Rolling Meadows/Bull Hill Master Traffic Impact Study SKP233

El Paso County, CO

June 25, 2024

Figure 17. Buildout (2028) Background Traffic Volumes and Roadway Classification

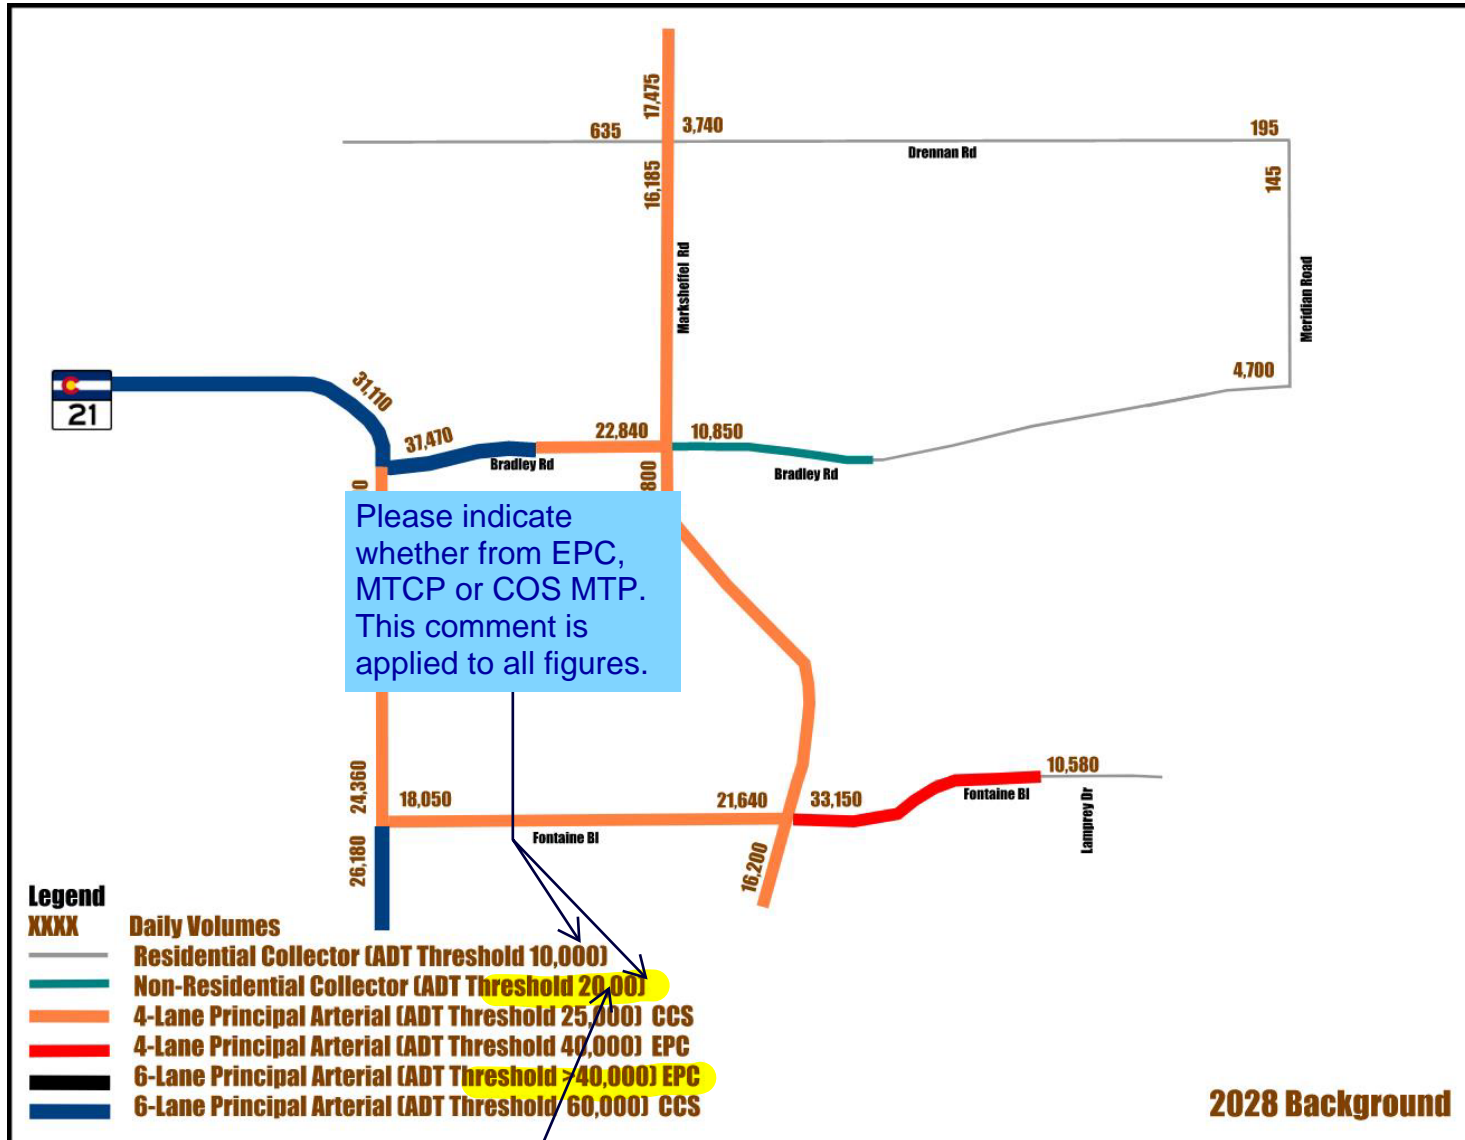
Review 2 comment: Please provide the peak volumes, intersection configurations, intersection operations (LOS), turn lane requirements and accompanying narrative for the background conditions year 2028 and 2045 as done in the previous submittal.

Review 3 comment: As indicated in our email correspondence on 5/8/2024 to Scott Barnhart; Please provide the additional narrative discussions and tables previously submitted. In that email we eliminated intersection configurations and turn lane requirements from the above. See snippet from email below.

Please provide the peak volumes, intersection configurations, intersection operations (LOS), turn lane requirements and accompanying narrative for the background conditions year 2028 and 2045 as done in the previous submittal.
